Single storey front & rear extensions
13 Sutton Avenue Rustington

Thank you for your internet representation made on 21st August 2015 which has been recorded as '**an objection**' with the comments as follows:

REAR

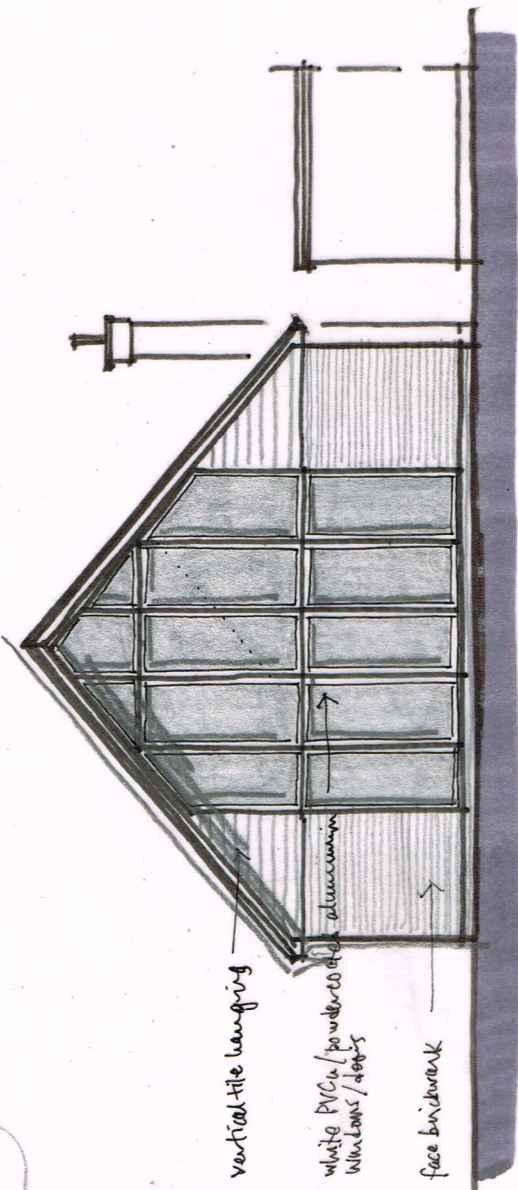
The proposed extension to the North (rear) follows the higher of the two ridge lines ending in a fully glazed gable. The height of the roof line with the fully glazed gable would be overpowering and domineering to our property and would not fit in with the designs of the neighbouring bungalows. An extension following the lower ridge line would be less intrusive. The footprint of the extension is fully acceptable. We have no comment on the proposed extension to the front (south) side. We have discussed these comments with Mr Carter.
